Online Comment

Application H17-0504-19
Location Off Stockhouse Lane Surfleet Spalding PE11 4AU
Proposal Erection of dwelling - Outline approval H17-0242-17

Name Rights of Way & Countryside Access
Address Environmental Services - Andy Savage Lincolnshire County Council Unit 7, Witham Park House LN5 7JN

Date Submitted 28-05-19
For/Against Comments

Job Title Proposed Dwelling Land adj. 23 Stockhouse Lane Surfleet, Spalding For Mr & Mrs Bennett	Date July 2019	Drawn by GG Checked by GE
Drawing Title Planning Drawing Site Plan and Location Plan	Job No. SE-1163 Dwg No. PP1000	Sheet Size A1 Revision 06

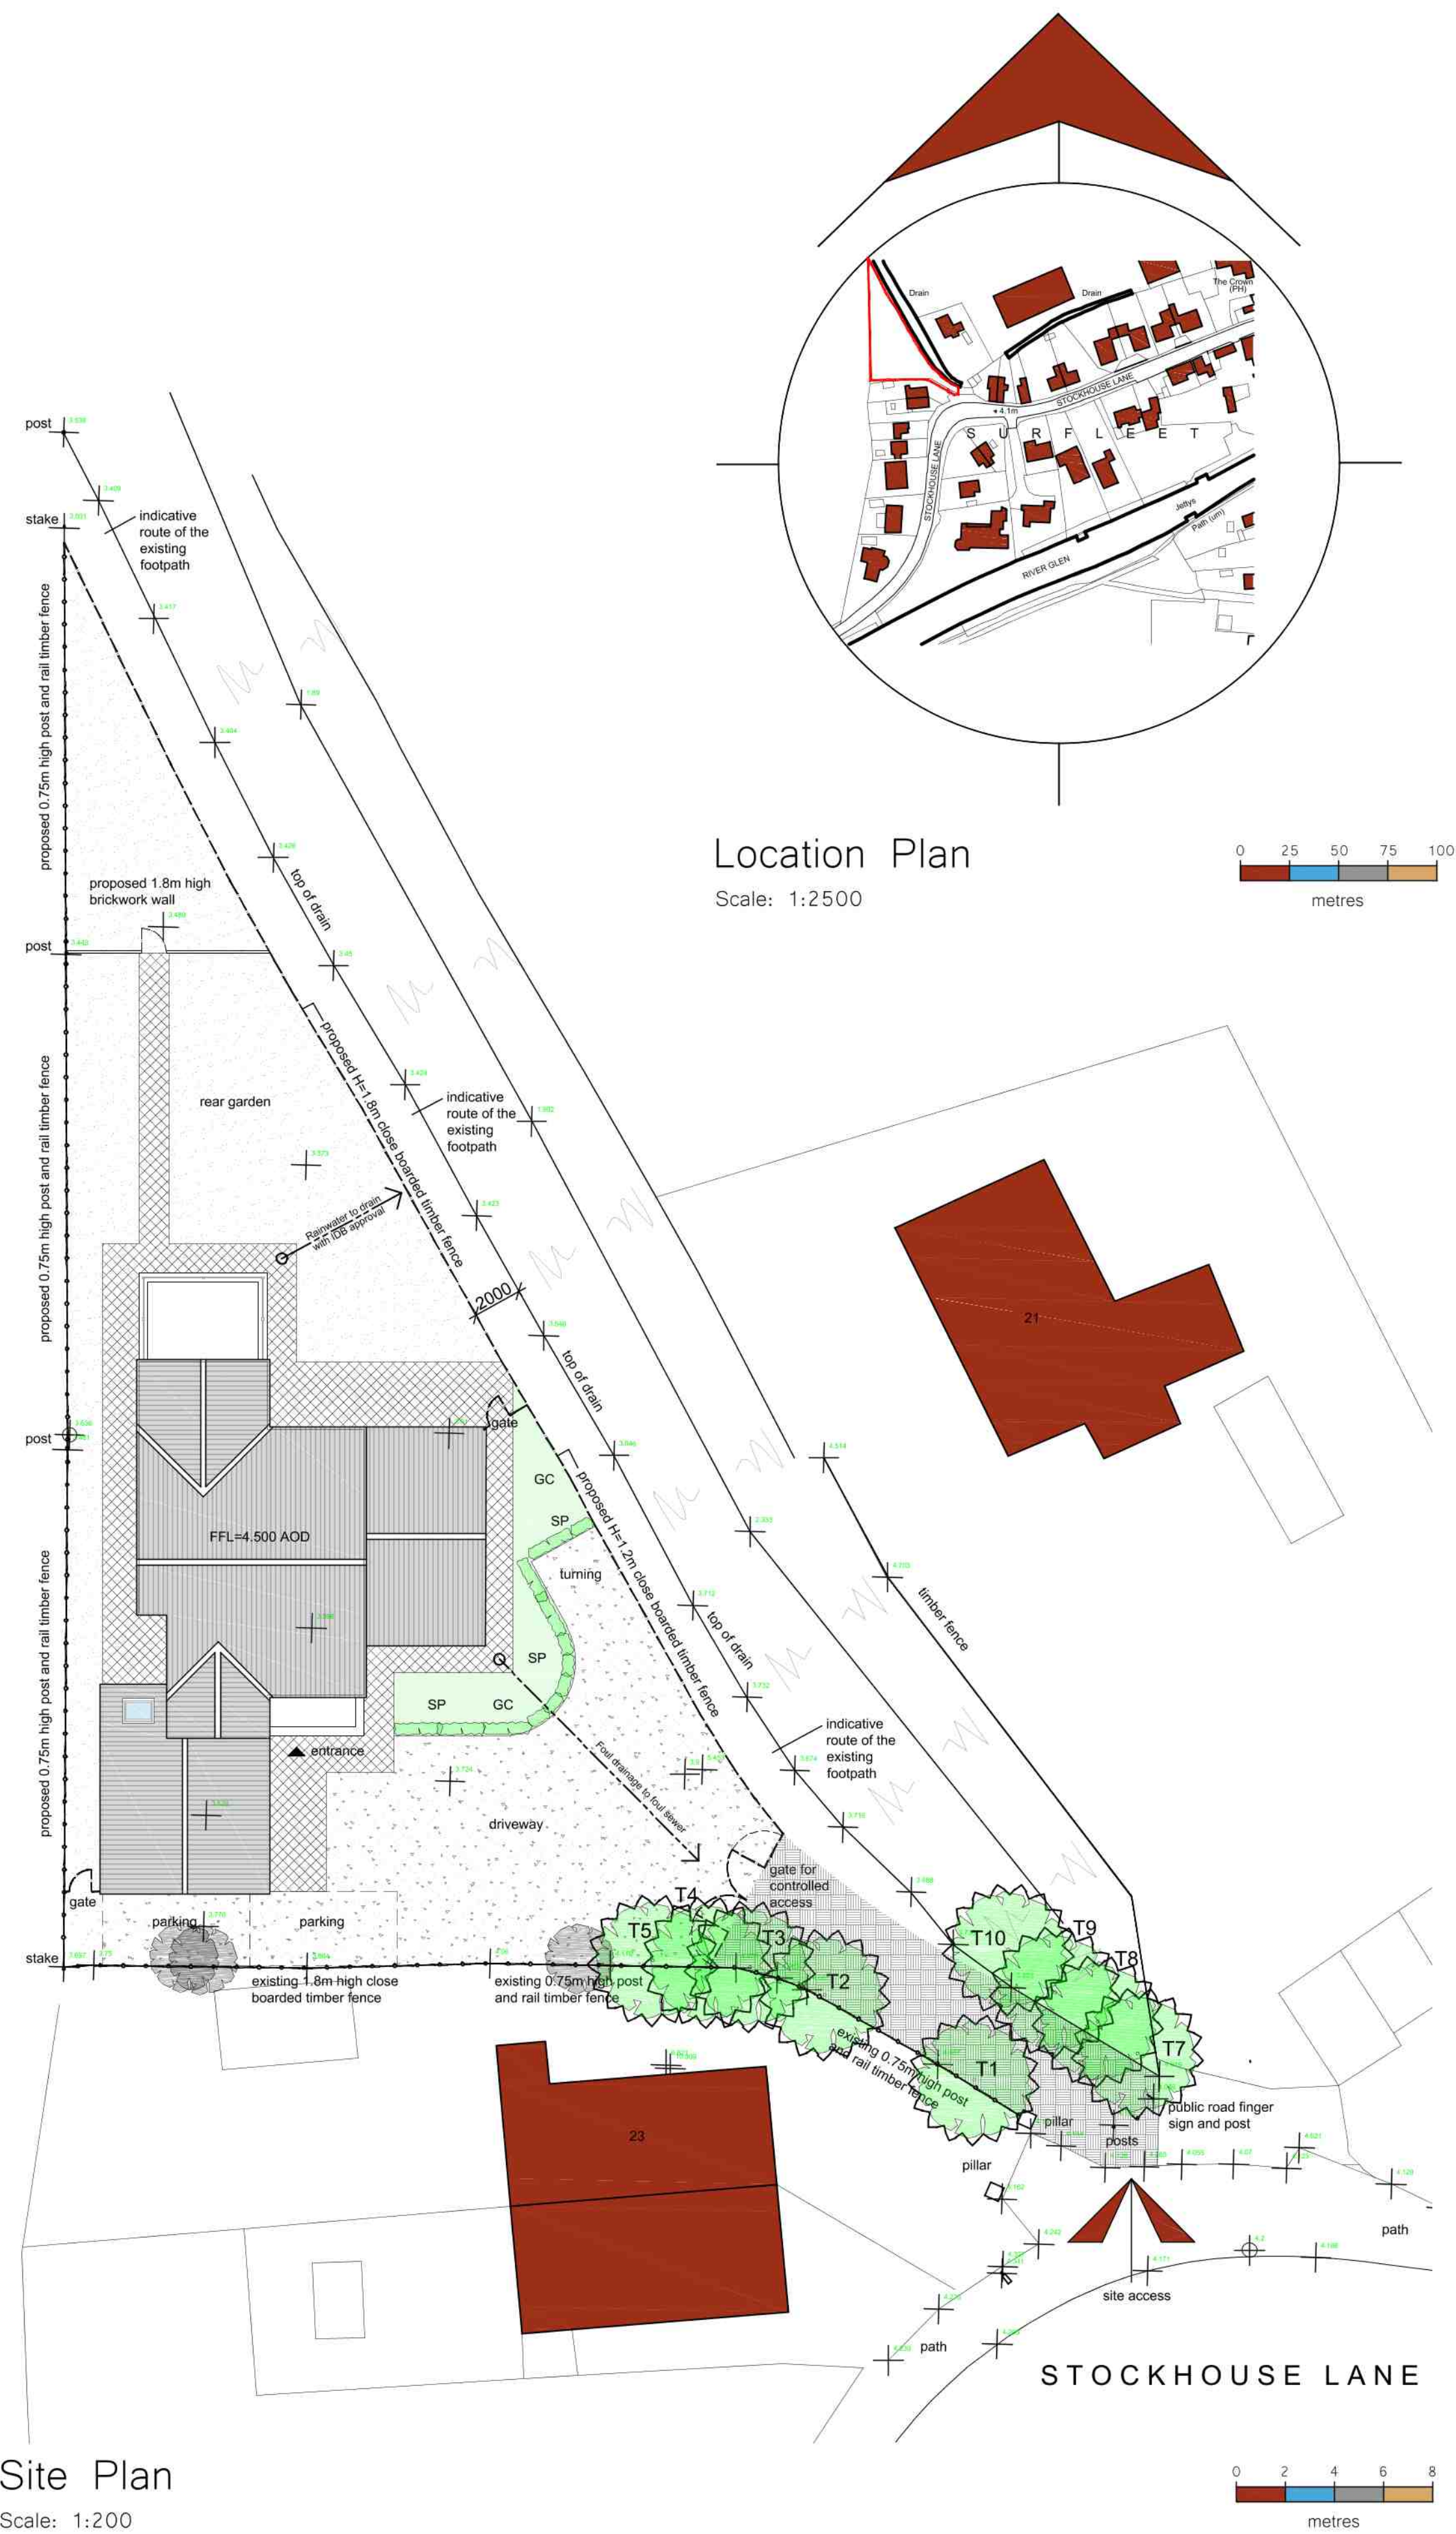
The proposed development affects Surfleet Public Footpath No. 5 - plan attached to previous correspondence.

1. In the absence of any further information, it is expected that the definitive line and customary width of the path will not be affected by any proposed development.

2. A level minimum width of 2m should be retained to accommodate the footpath.
3. No gates should be erected across the public footpath or gate posts erected at either side of the path.

4. During any works allowed by this proposal, users of the public right of way should not be inconvenienced or exposed to hazards by any such works.
5. The layout plan indicates that the section of footpath which passes along the drive will be surfaced. The County Council must be consulted on the type of aggregate to be used and the specification of works before any materials maybe installed on site.
